Consultation Response from: KC Environmental Health (Pollution & Noise Control)
2023/91801 - Land to the North of, Cumberworth Road, Skelmanthorpe, Huddersfield, HD8
Discharge condition 12 (phase 1) (Remediation Strategy) on previous permission 2019/90151 for erection of 190 dwellings and associated landscaping and infrastructure
Date Responded:
 17th July 2023

Condition 12 – Phase 1 Remediation

Plots 8 - 10 – Overall membrane layout

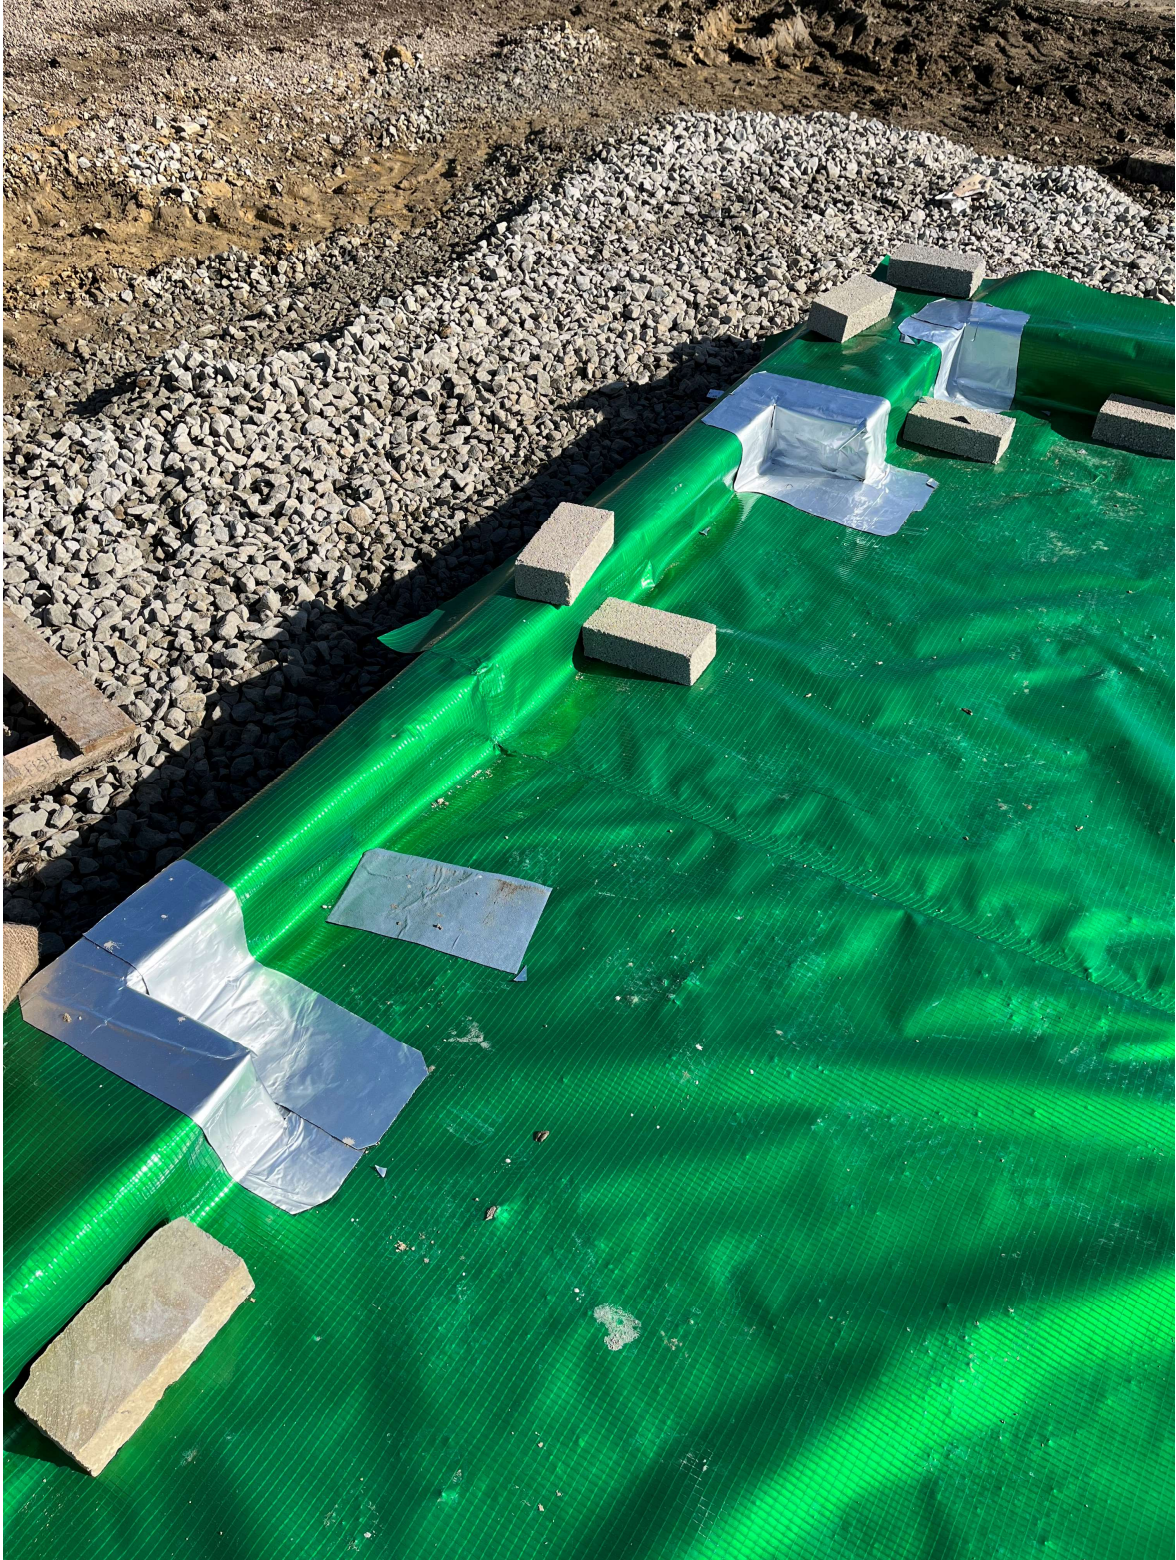
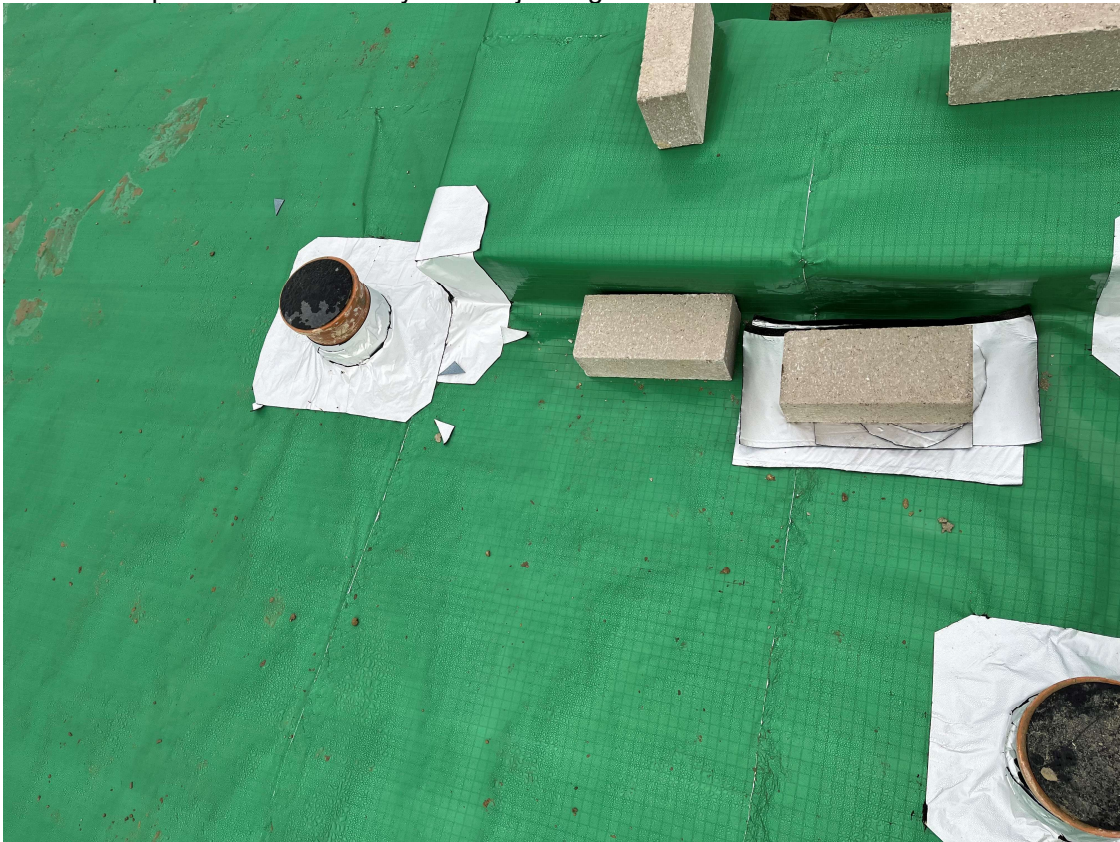
The photographs suggest the absence of surface preparation prior to laying the ground gas membrane (see photographs on Page 10 and 11 of the report). This can compromise the gas

membrane. As per good practice guidance, debris is likely to pierce gas membrane. Therefore, the applicant must provide the LPA with the necessary confidence that the membrane was not damaged and has been installed correctly at these plots.
